Your Ref: OWPC17258
Our Ref: FP/312/17/HH 19-12-2017
Please ask for:
Mark Jones

Demolition of attached garage & addition of two storey side extension.
50 Crossbush Road Felpham

Proposed Extension and Alterations
at 50 Crossbush Road, Felpham
for Mr B Brogan
Drawing P02 December 2017 Scale 1:100 @ A3
Planning Drawing - Ground Floor Plan & Elevations

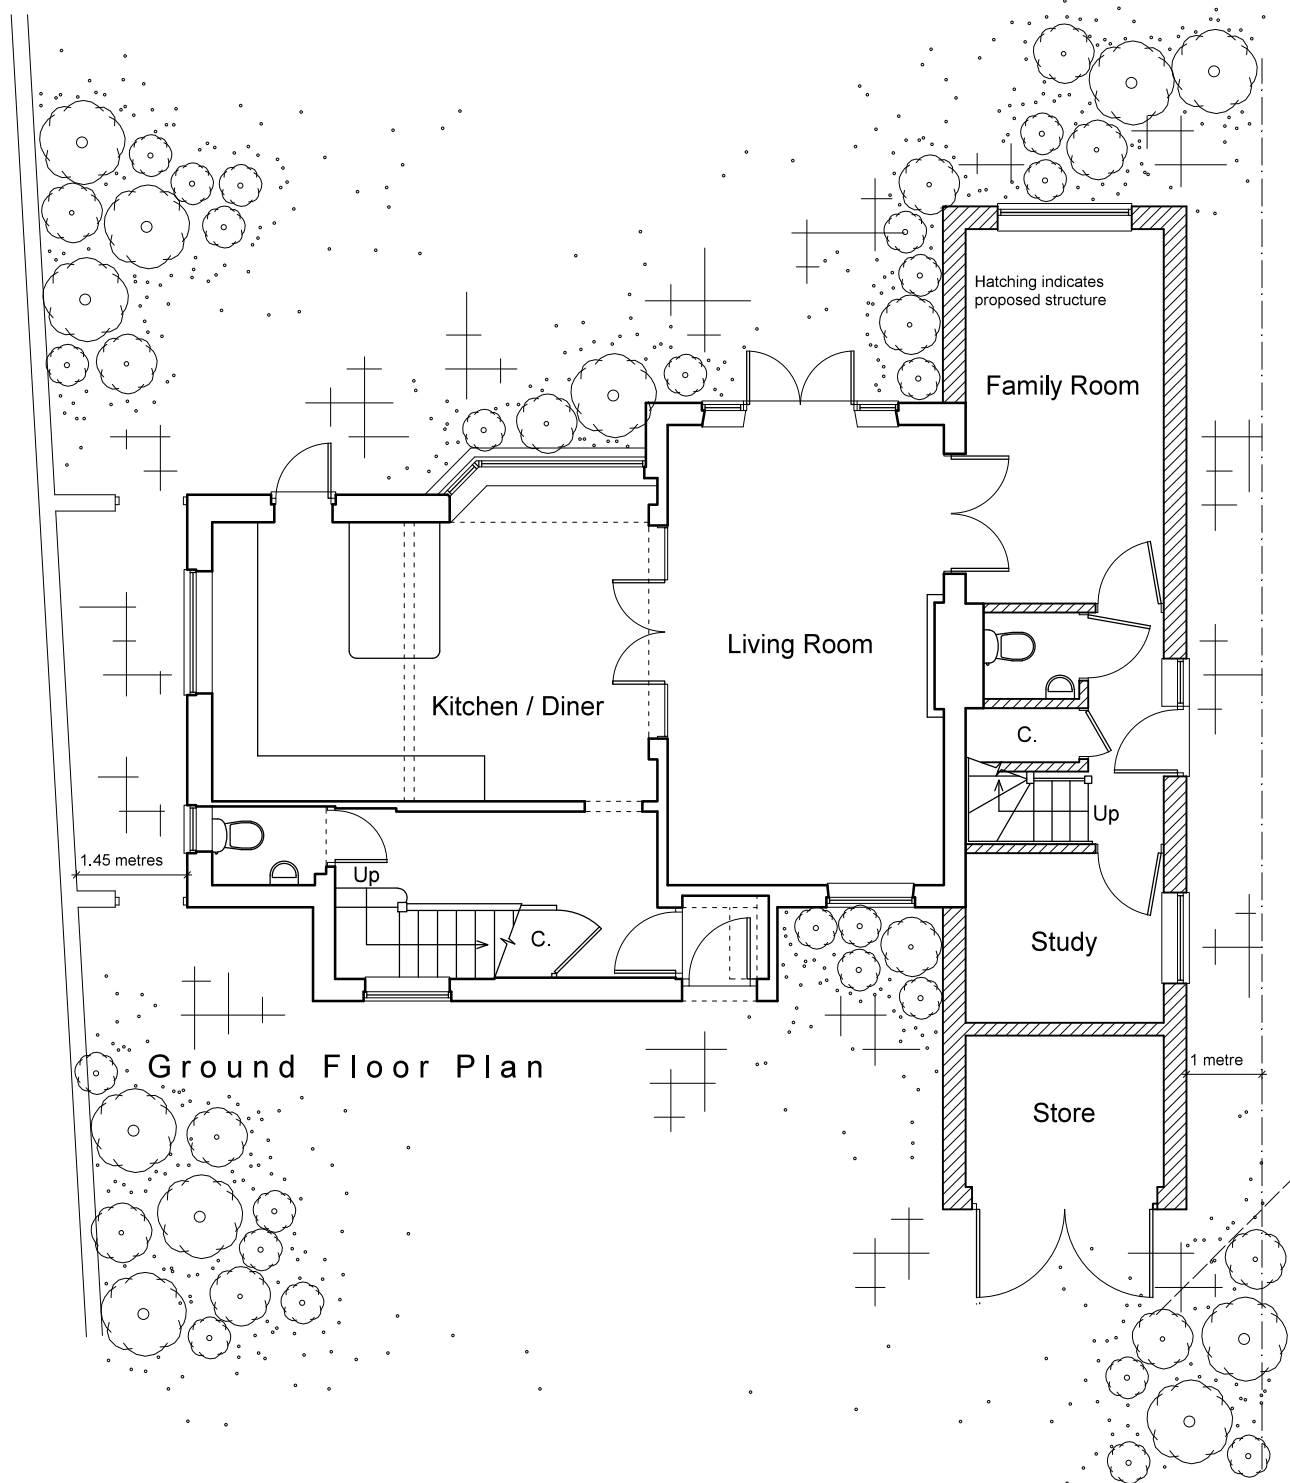
I wish to object to the proposed scheme to build a large 2 storey extension close to the side of my house, which will drastically reduce daylight to my kitchen, toilet, utility, playroom and bathroom reducing the enjoyment of my home. It would not be so bad if it were single story.

Furthermore, the extension is shown projecting approximately 5 metres in front of the existing single storey garage that it replaces, and being two stories in height it will be intrusive and will overpower the appearance of my house when viewed from the road. I consider that an annex in this location would constitute an over-development of the site, and would be unneighbourly and detract from the general character of this pleasant residential area.
